<p>Principal Areas of Disagreement Summary Statement PADSS from Network Rail Infrastructure Limited</p>	<p>Version Number: 2.0 Submitted at: 06/06/2024</p>
--	--

Gatwick Northern Runway proposal: draft rail mitigations

Diagram 5-4: Gateline locations, Gatwick Airport Rail Station

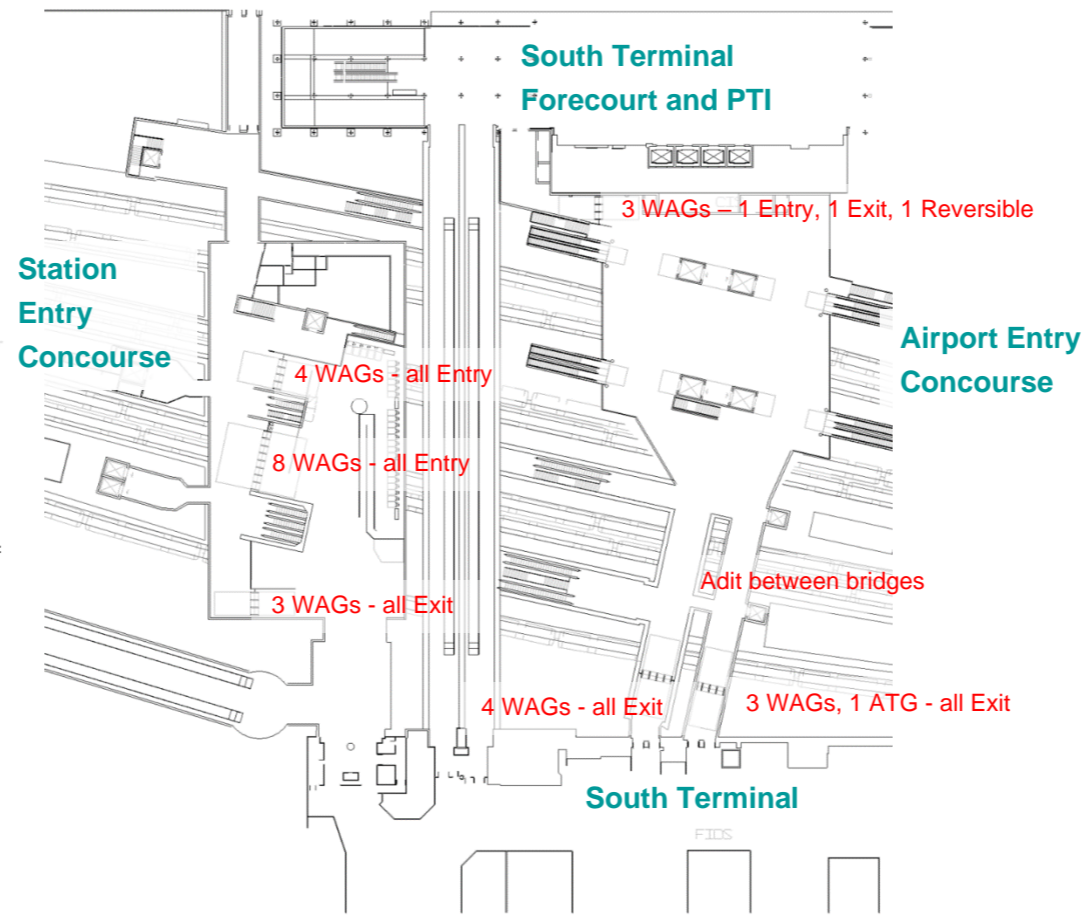
<p>3.4. Gatwick Airport station capacity is a concern with future passenger levels</p>	<p>The Gatwick Station Project has substantially increased passenger capacity and has transformed the journey from train to plane and given passengers travelling between Brighton and London easier, faster, more reliable journeys.</p> <p>The Gatwick Station Project delivers additional capacity but explicitly did not account for the impact of the Northern Runway Project. The evidence provided in the Transport Assessment indicates a particular issue with congestion at two of the ticket barriers (gate lines) due to the extra passengers arising due to the scheme, which requires further investigation and potential mitigative measures.</p> <p>Network Rail have undertaken a high level quality assurance exercise of Gatwick’s station capacity modelling. This has included comparing gateline throughput to observed data, as well as understanding the current spread of passengers across the gatelines.</p> <p>Network Rail’s conclusion is that the station modelling is sufficiently robust in its distribution of passenger across the northern and southern overbridges and gatelines – modelled distribution is in line with observed distribution from April 2024.</p> <p>The model assumes a slightly faster throughput of the gatelines compared to observed, but this is partially offset by observed data indicating instances of greater use of the southern gateline compared to the modelled analysis.</p> <p>As the modelling does broadly reflect the current operational situation, Network Rail are confident that there will be congestion at the arrival gatelines in the future as passenger demand rises, and the Northern Runway Proposal will add to this congestion.</p> <p>Consequently, we do not agree with Gatwick’s conclusion that “the Project does not require any additional mitigation works to Gatwick Airport station” (Transport Assessment, p. 83).</p>	<p>Network Rail have identified mitigation measures which would reduce congestion at the arrival ticket gates in the future. These are attached.</p>

1.a	Train station capacity	Additional Wayfinding	Capex	Very low	Increased spreading of passenger demand over the two gatelines.	GAL to commit to fully fund and monitor effectiveness of signage at reducing issue.

1.c	Train station capacity	Removal of all gates	Capex & Opex	Low	Alternative to 1.d – removes congestion but introduces significant revenue protection risk.	GAL to fully fund a jointly-sponsored (with NR and GTR) study into gateline capacity / station operational review prior to runway opening. GAL to fund any resulting recommendations.

1.d	Train station capacity	New Gateline in South Terminal	Capex	High	Alternative to 1.c to help resolve congestion. Would require land take from GAL to NR.	Network Rail note that this intervention is likely to have greater effectiveness at mitigating gateline crowding compared to 1a or 1b.

1.e	Train station capacity	Use of Platform 7 exit route via PTI Building	Capex	Low	Would provide additional capacity during peak periods of congestion but introduces a poor passenger experience via a longer route and is only effective for Platform 7 passengers.	GAL to commit to fully fund (if aforementioned review (item 1d) finds that a new platform 7 exit would be required).
2	Rail network capacity (refer to PADSS 3.1 and 3.2)
